From:	Timothy Lock <tim@gologic.us></tim@gologic.us>
То:	Jean Fraser <jf@portlandmaine.gov></jf@portlandmaine.gov>
Date:	5/14/2014 2:59 PM
Subject:	Re: 97 Cumberland Avenue - level III Site Plan and Subdivision Review

> Together with my colleagues (Urban Designer Caitlin Cameron and Director of Planning Alex Jaegerman) I coordinated a formal design review based on the R6 infil alternative review standards.

> We would appreciate seeing the following so we can finalize the design review:

A1.2

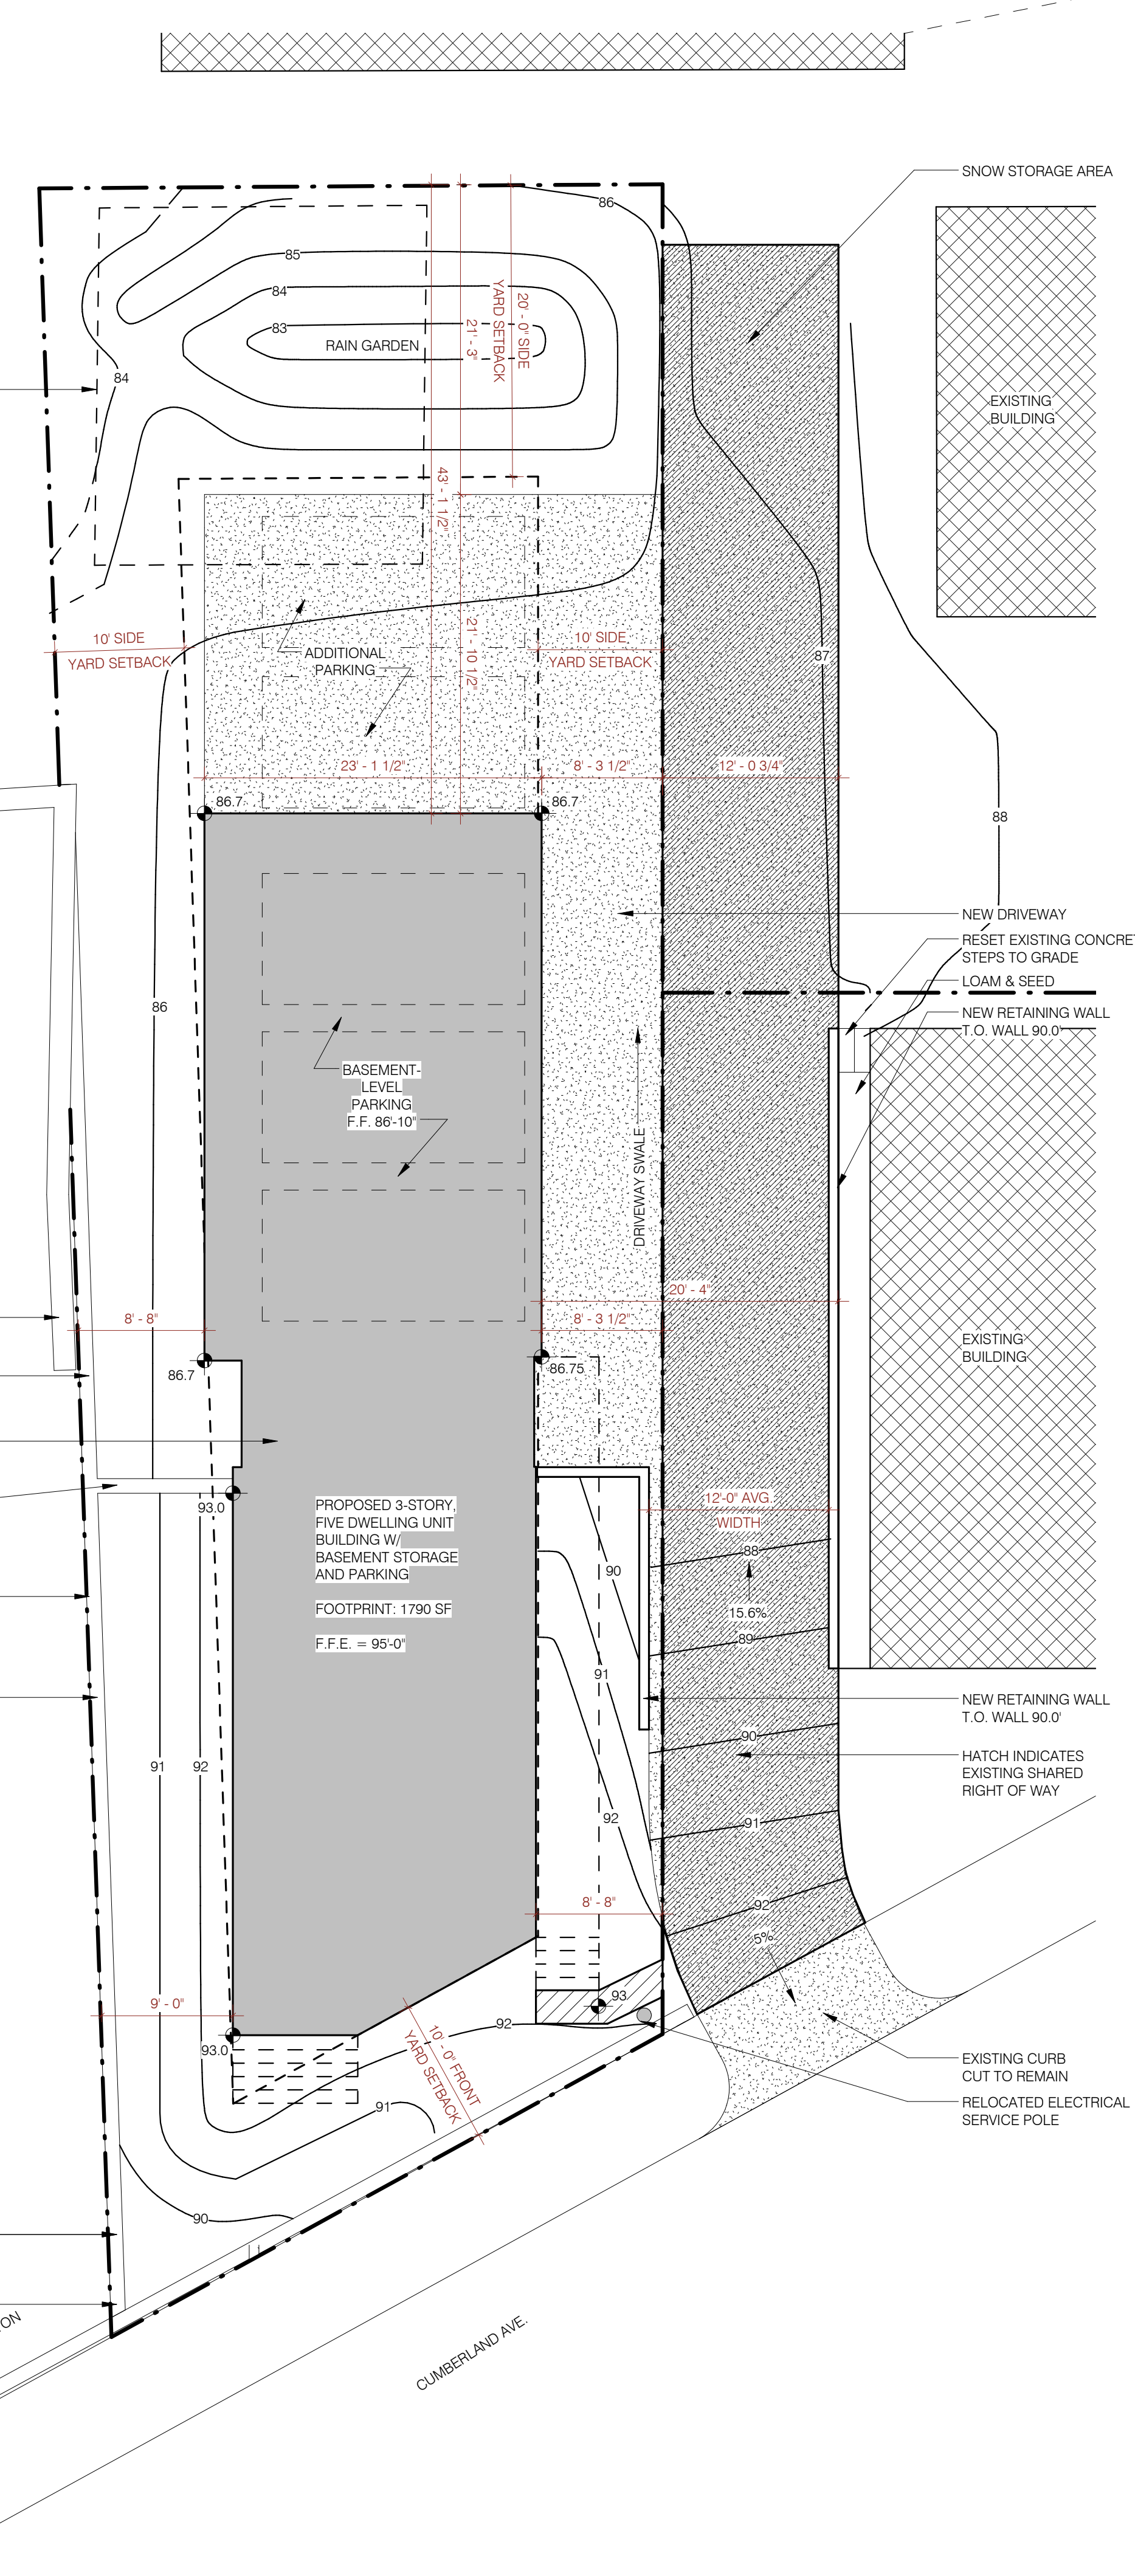
to achieve compound pitches; we can draw the solar panels on the roof plan and resubmit > 5. How far are the upper stories set back on front elevation- could that be indicated on a plan that also shows the location of the abutting house?

> 6. Some renderings show the fence and others don't. We do not consider the fence meets the standards in that it appears an interruption rather than a transition. We would like to see the details of the area between the building and the sidewalk in order to see how it relates to the street and how the entrances are handled (this could be on same plan as 3 above).

We can provide this

We can provide this, but am i correct in assuming you would rather not have a fence at all? if so, we would also prefer to not have a fence - it was my understanding that fences were encouraged.

A3.1

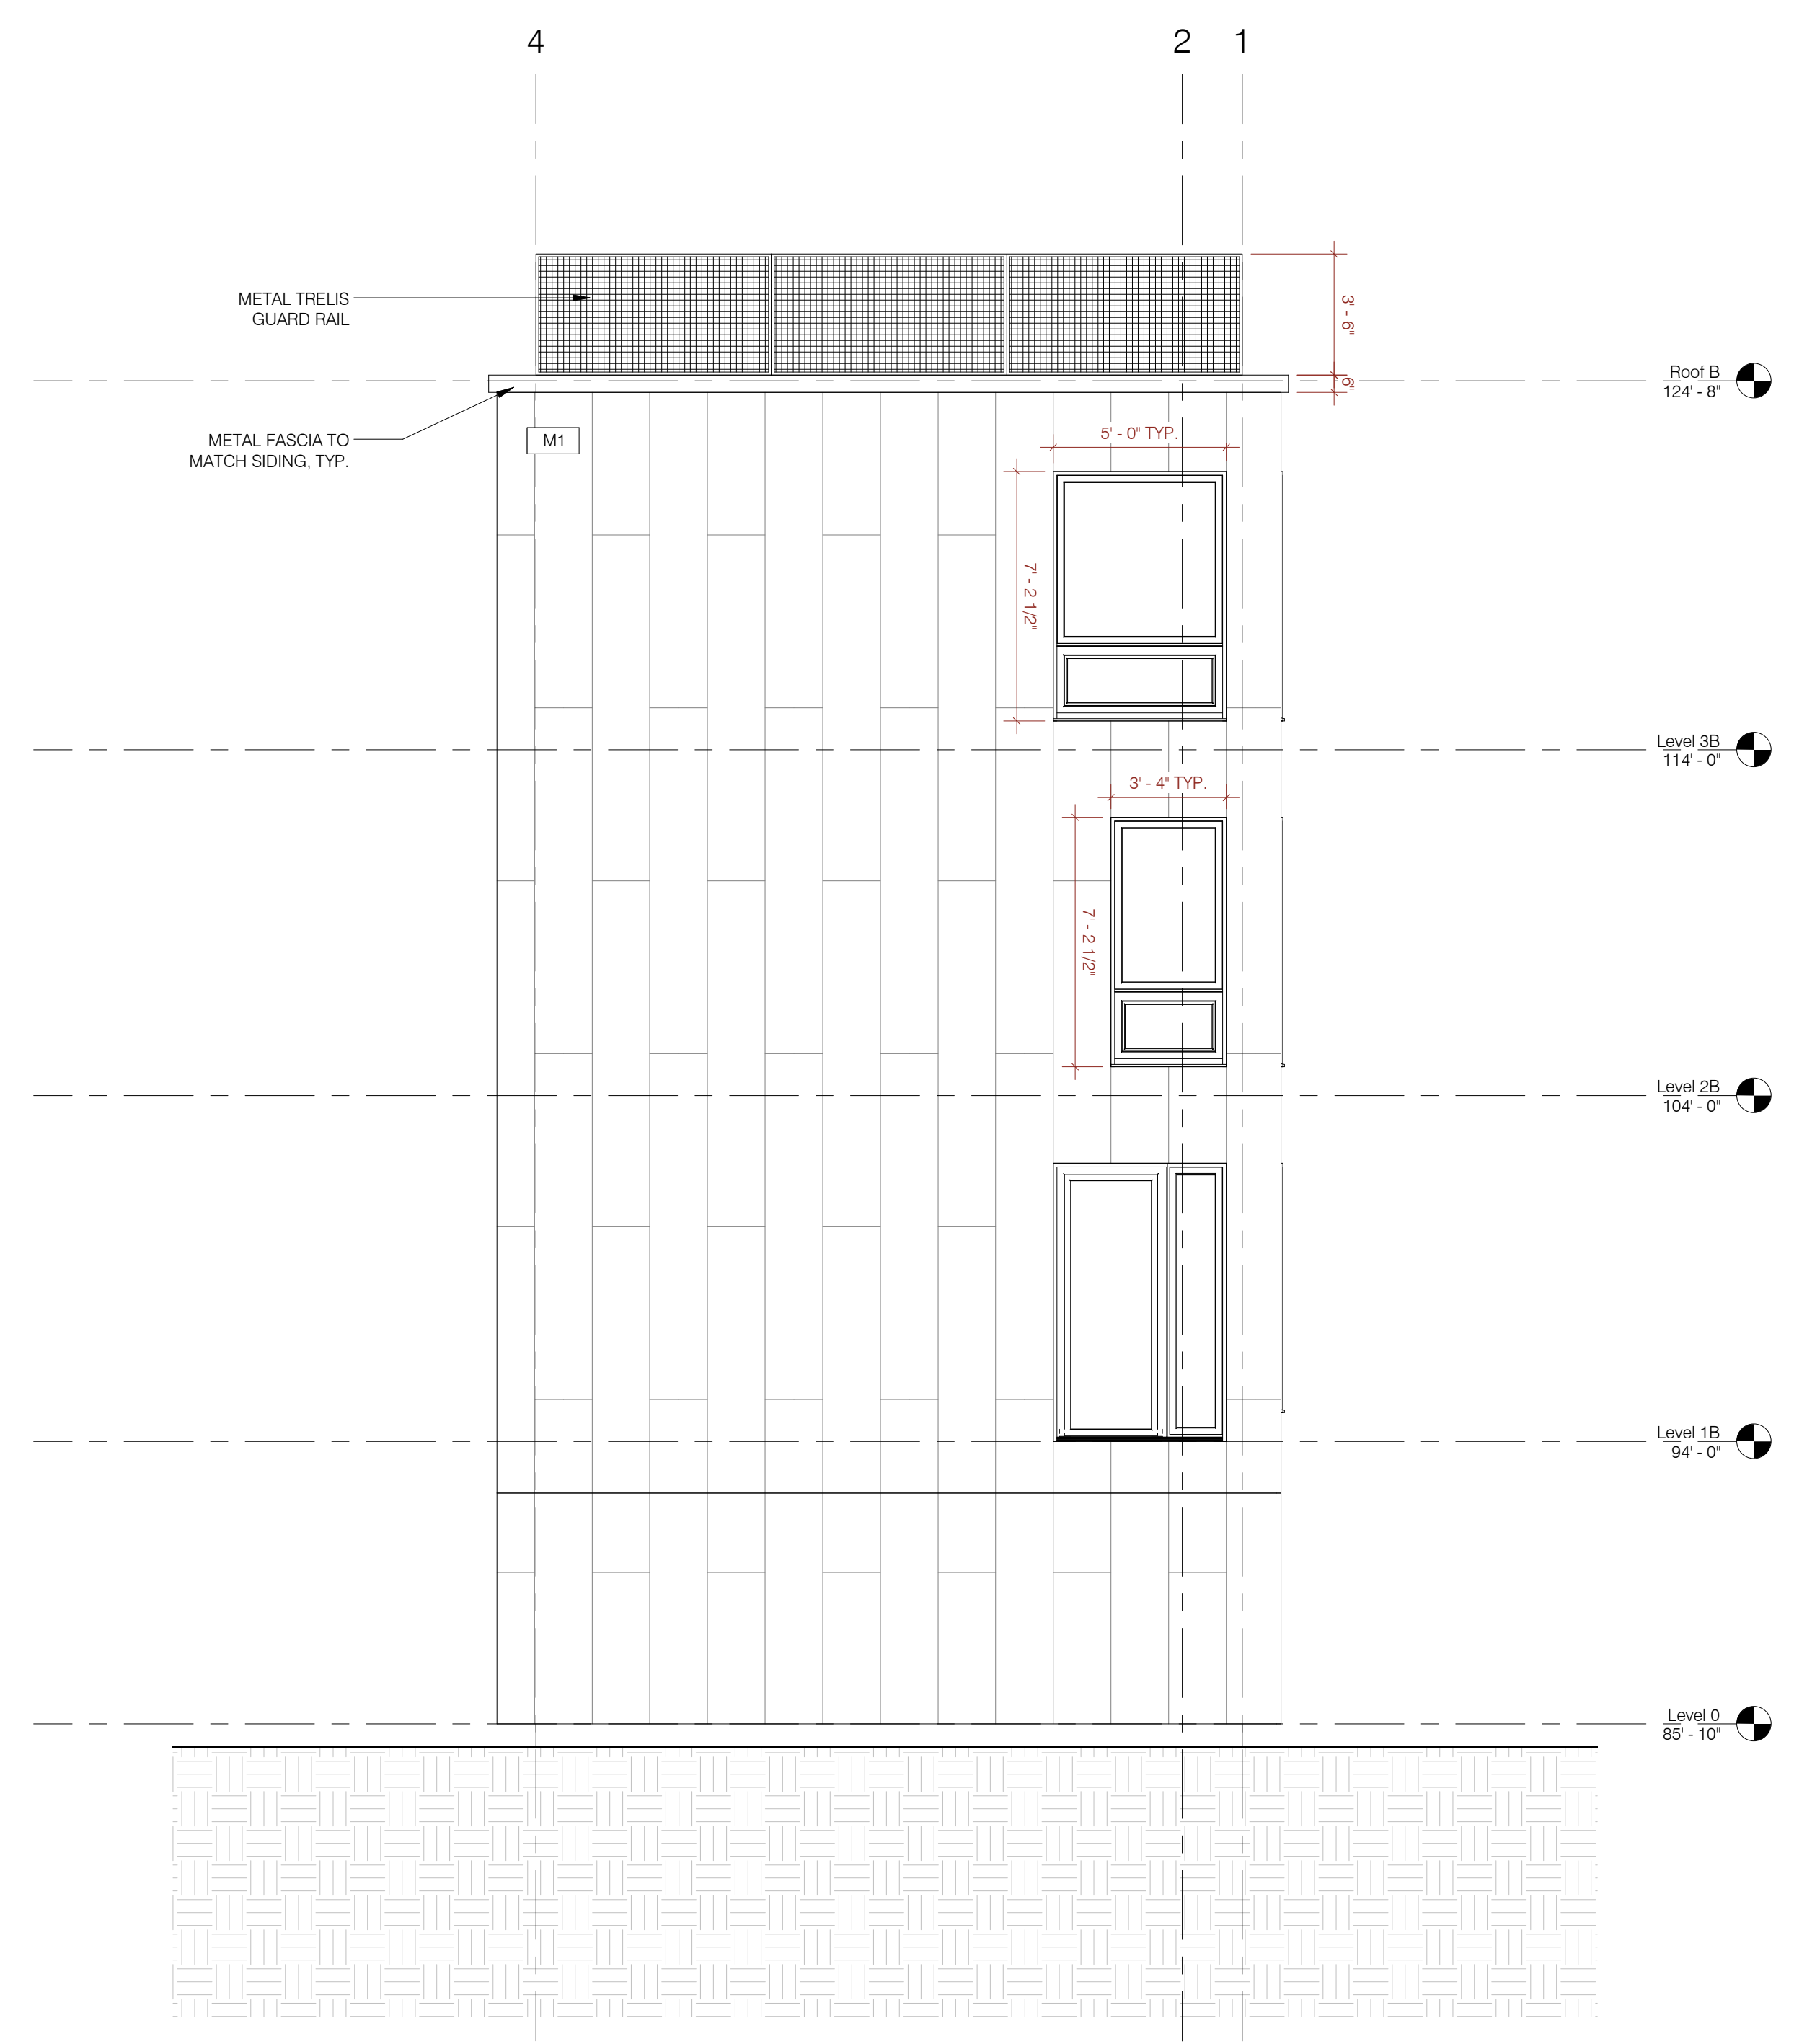
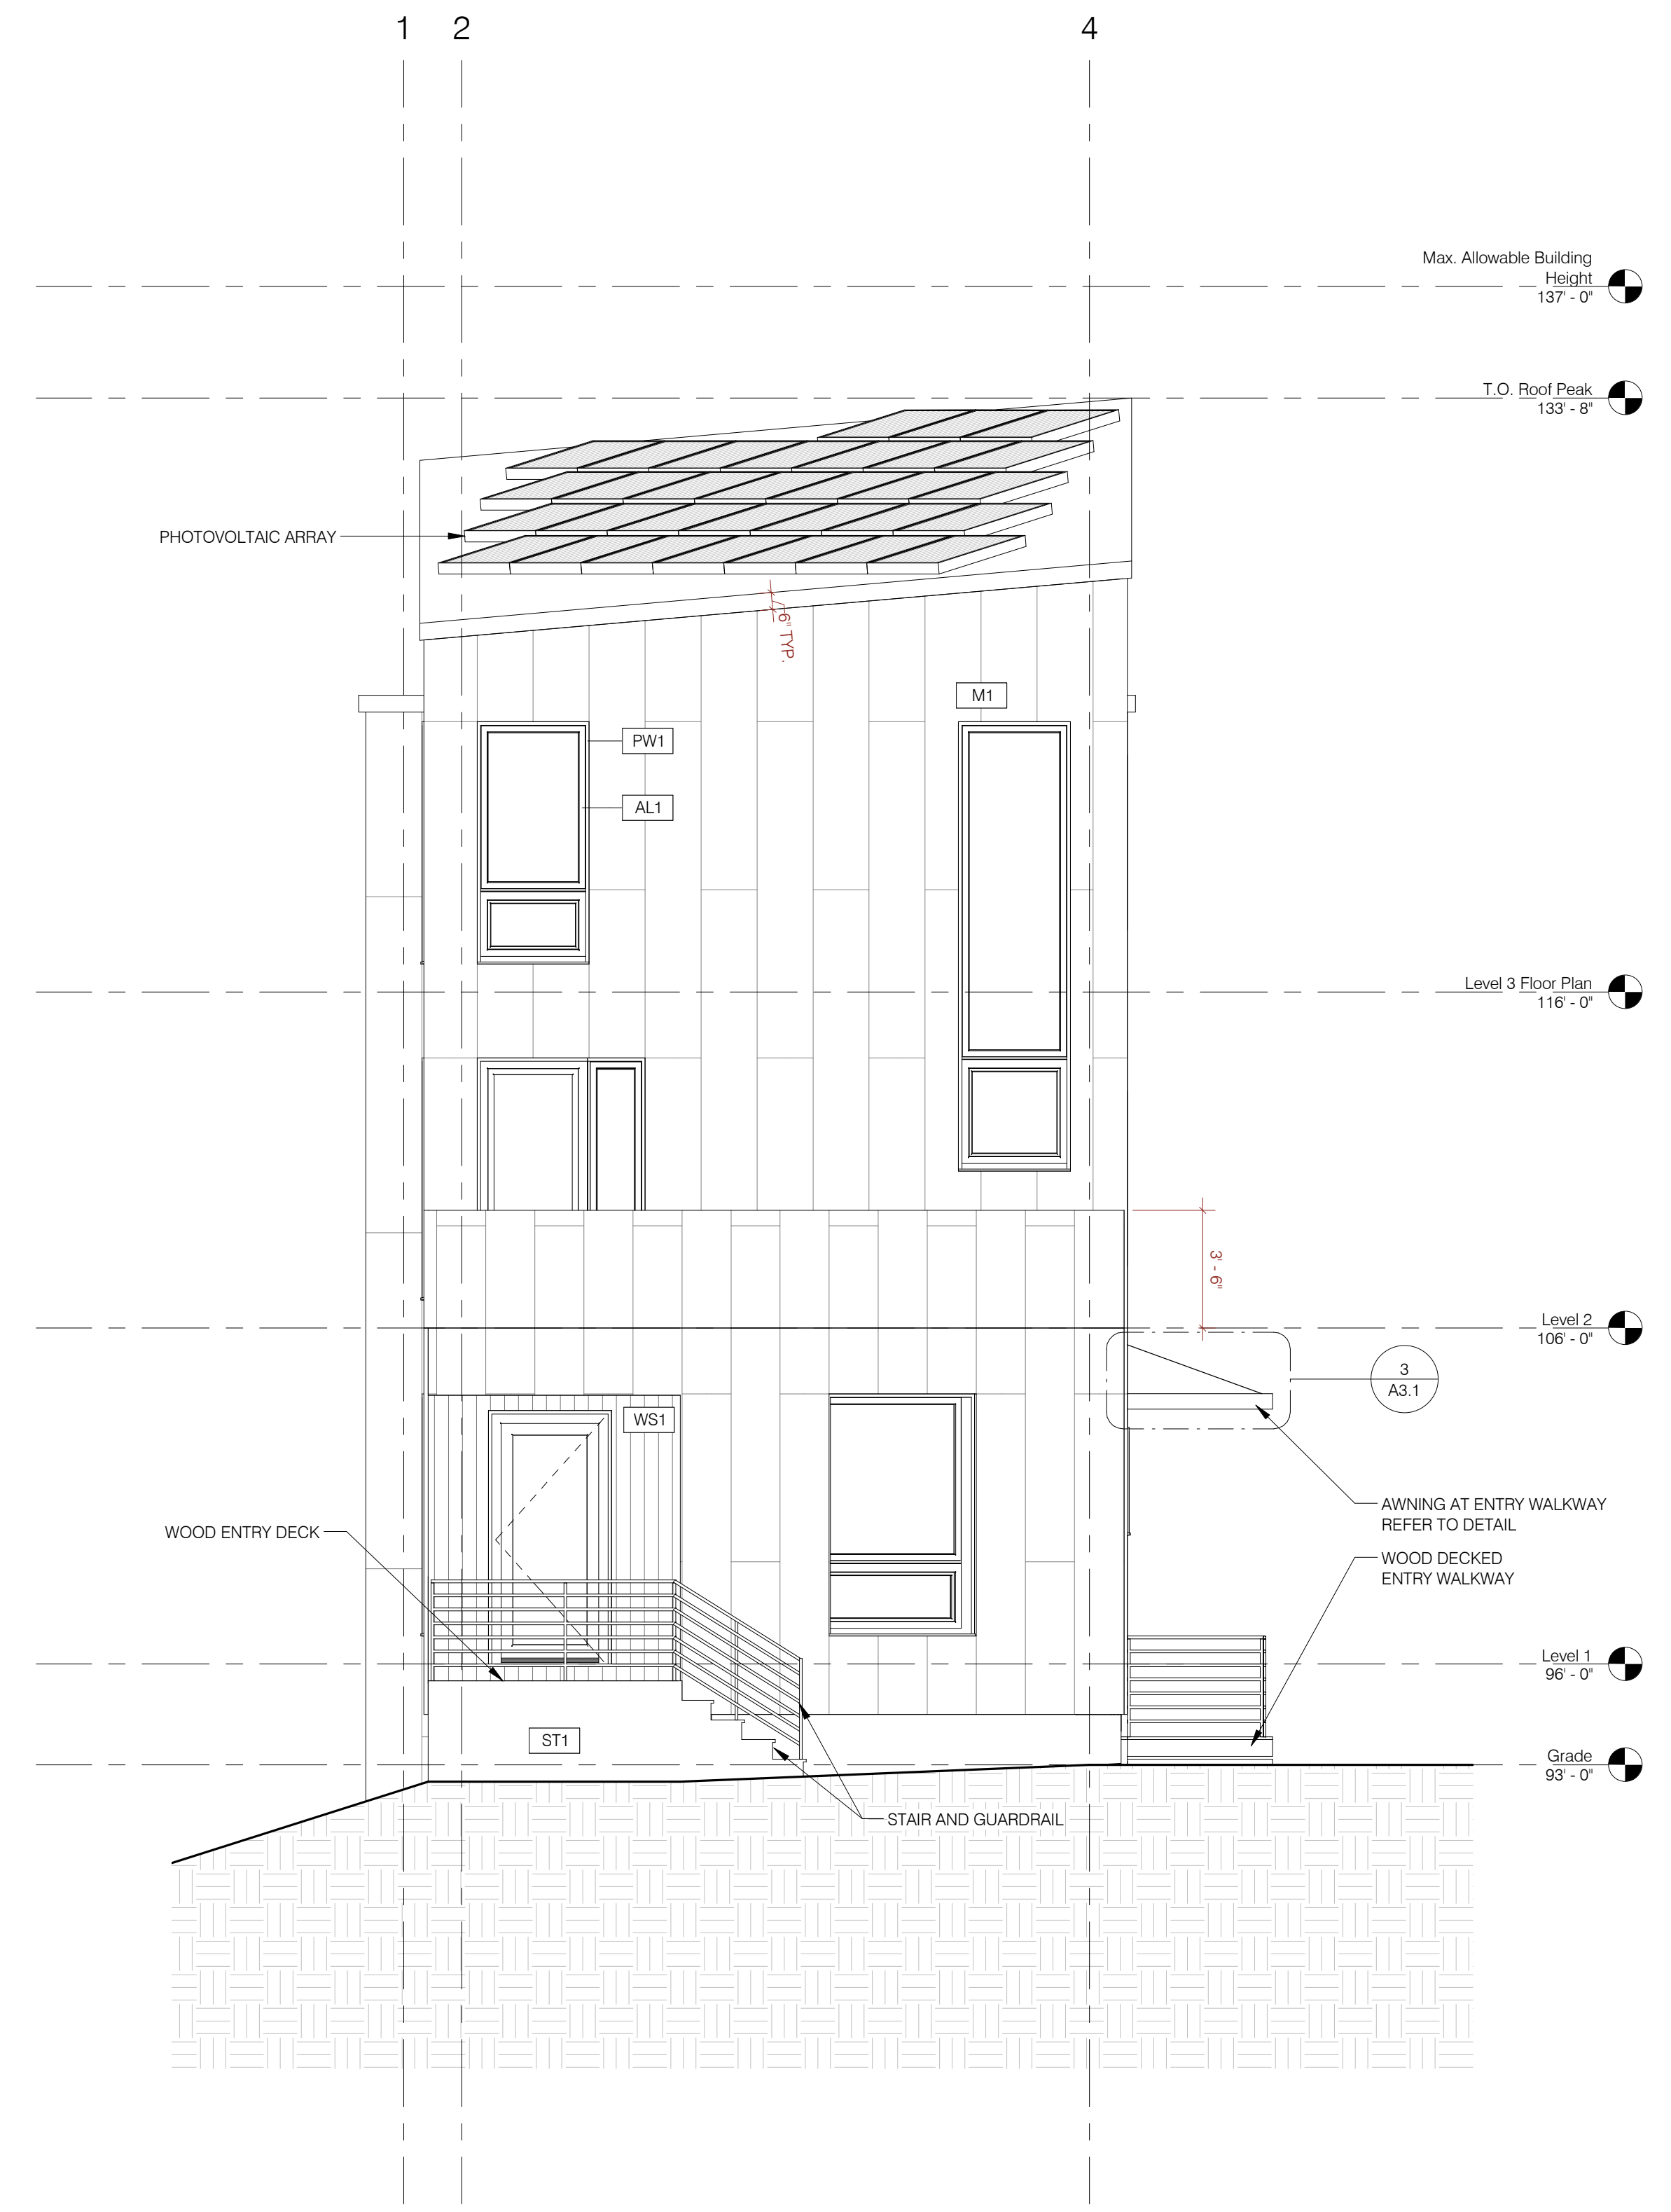
> 3. More detailed plans/elevation of front yard area and how a person gets from the sidewalk into the property- its not clear whether the door in the front elevation is an entrance or a deck, for example- so it needs to tie into the site plan to show walkways/paths etc; also the elevations show some side steps near the front door that are not shown in the rendering;

> 9. Could we see a spec/detail for the side awning?

> 10. What is the height of the FF elevation above the sidewalk grade? What is the height of the sill of the front ground floor window above the sidewalk grade?

We can provide this

We can provide this, yes.

The FF elevation is 3' above the highest point of the sidewalk (95' versus 93') - the sidewalk pitches down towards washington, though
